DECISION DELEGATED TO HEAD OF PLANNING

Application No: H21-0314-22 **Applicant:** Mr S Necker
Proposal: Proposed Dwelling
Location: 29 Station Road Tydd Gote Wisbech
Terminal Date: 18th May 2022

CASE OFFICER ASSESSMENT

Site Plan

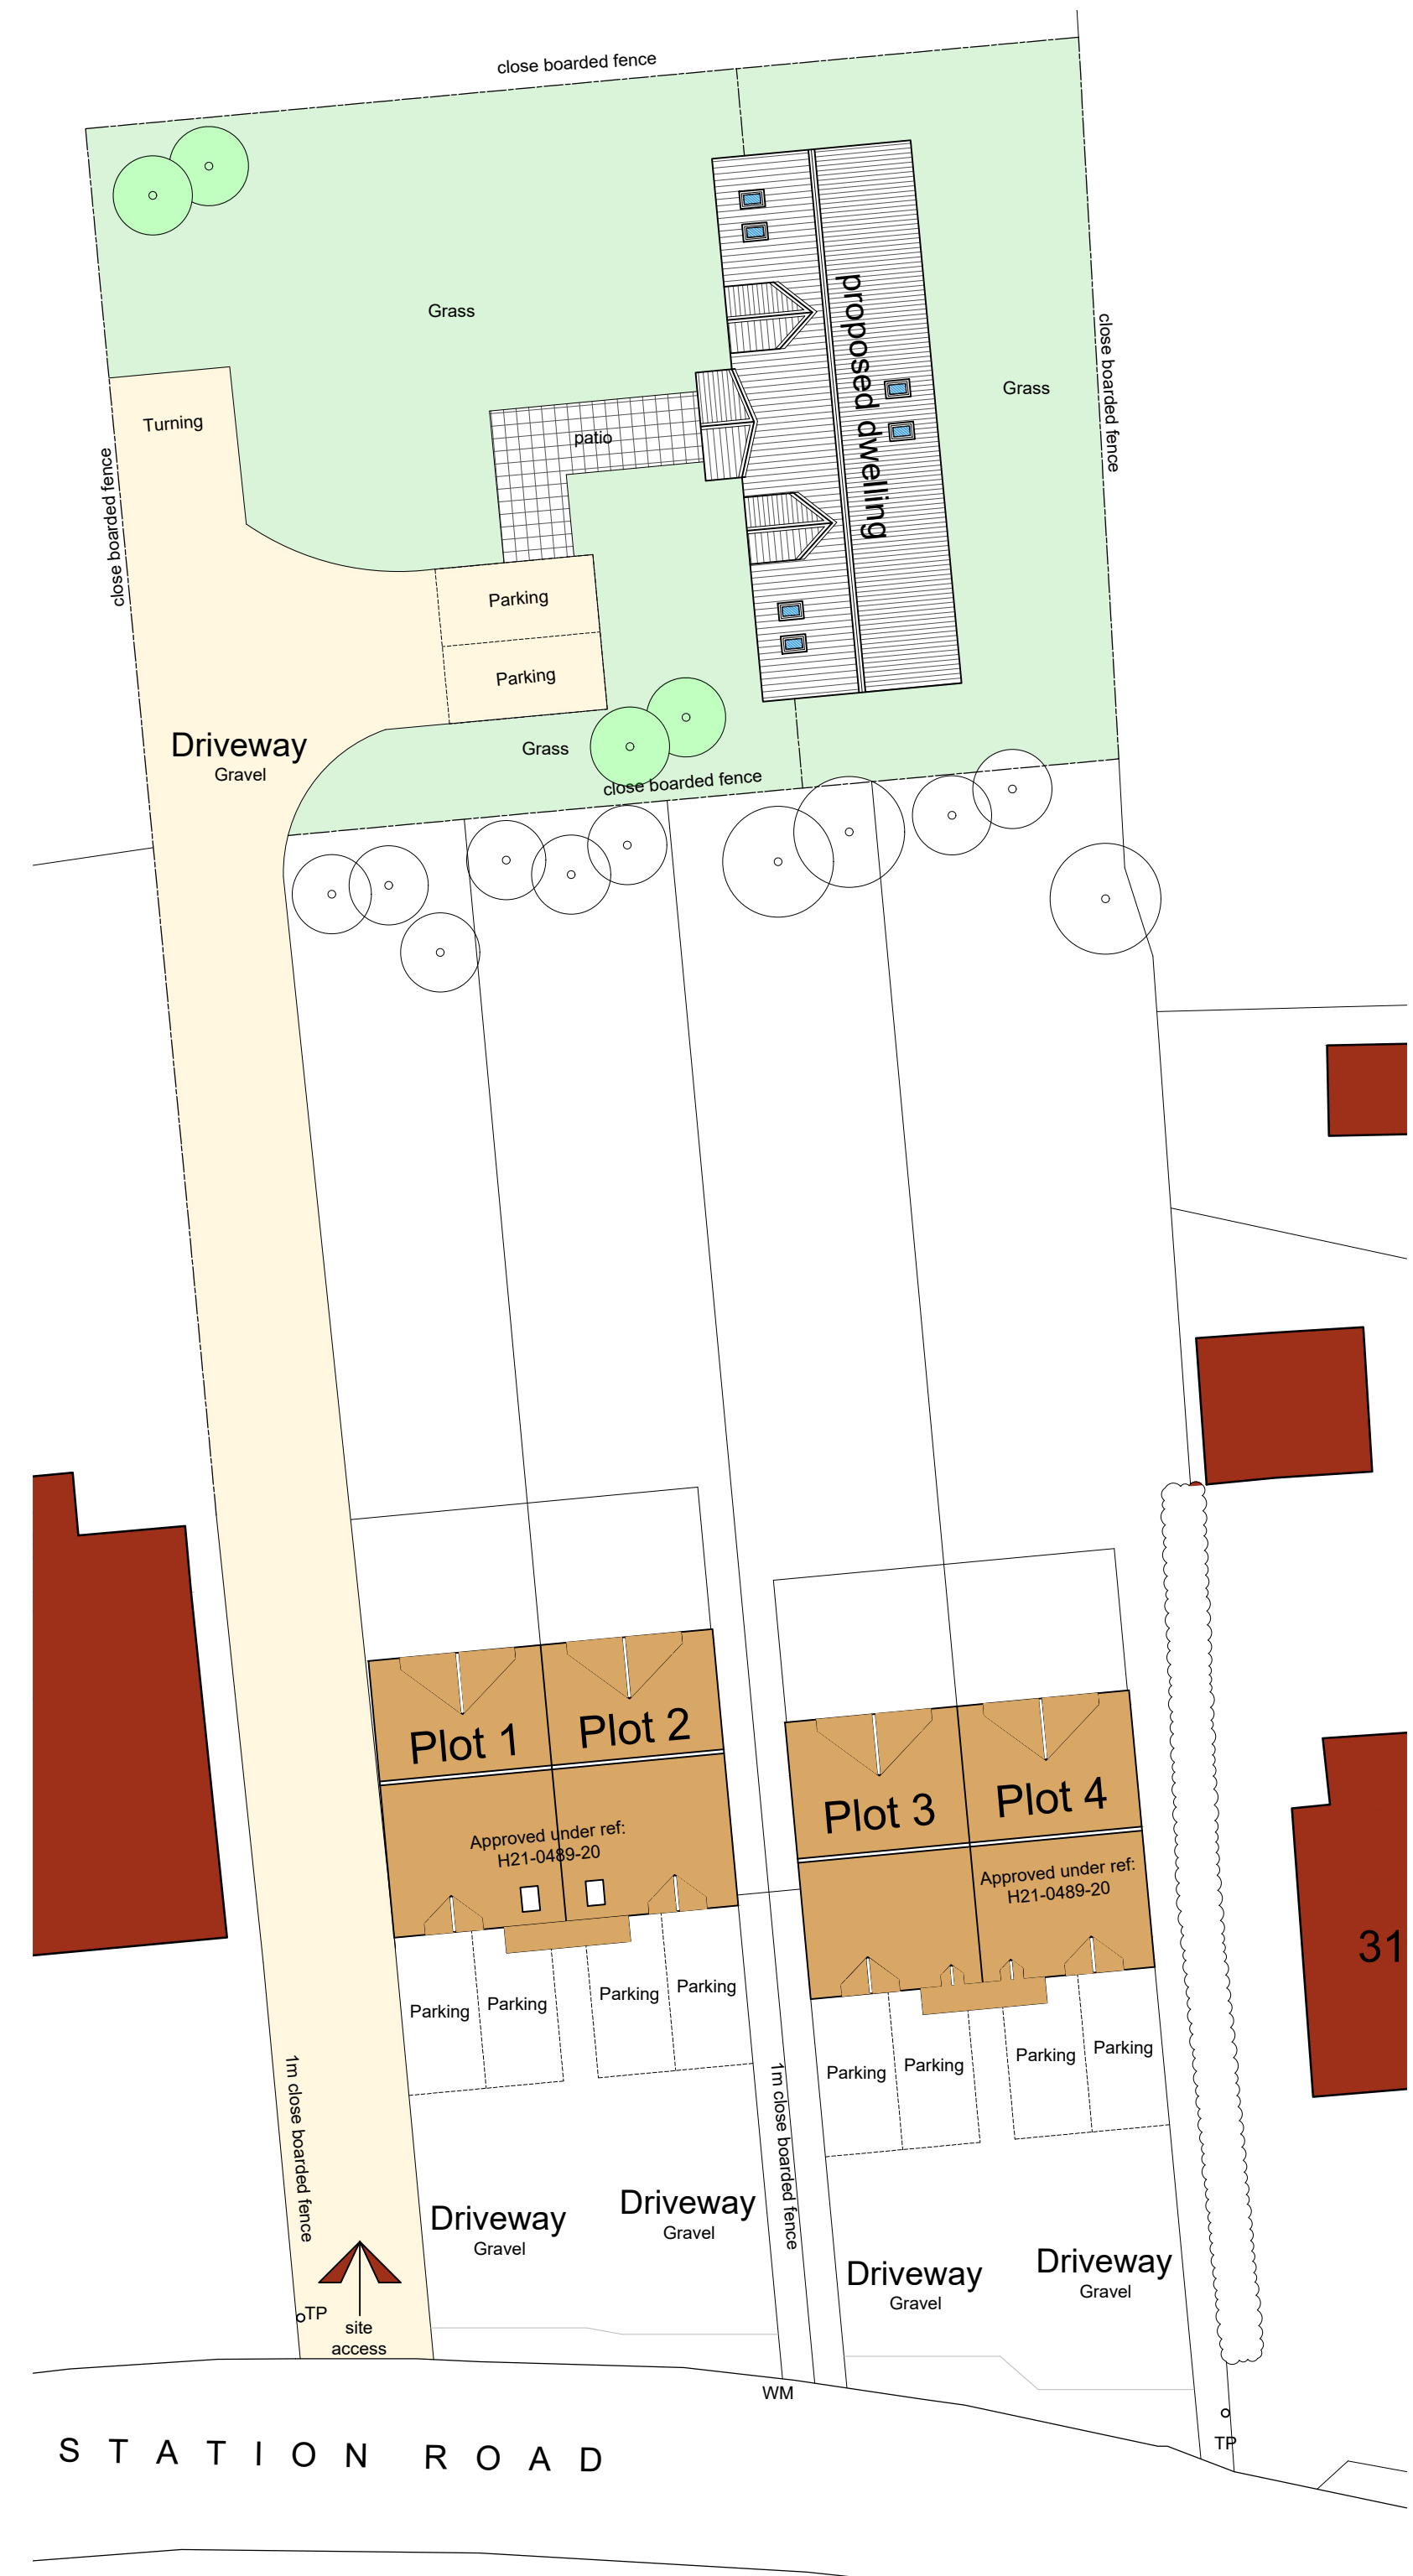
The proposal, which is served off a long private drive that fails to accord in design terms with the Authority's guidance note entitled "Private Drives - Waste Vehicle Collection Service", would result in the erection of a new dwelling beyond the existing settlement into an area defined as countryside within the SELLP. It would constitute an intrusive and inappropriate form of development that would urbanise, domesticate and significantly harm the rural character and appearance of the locality.

Planning permission has been granted for a garage block/domestic store in this location served by a gravelled private driveway (H21-0442-210). The dwelling would have dormer (bedroom) windows on its front elevation, plus rooflights serving ensuites. Two rooflights serving the staircase area would be positioned on the rear elevation. However, there is a degree of separation from neighbouring dwellings. It is considered that the proposal would not harm the amenity of nearby residents to a significantly greater degree in terms of overlooking, lack of privacy, overbearing effect, overshadowing, noise and disturbance, etc.
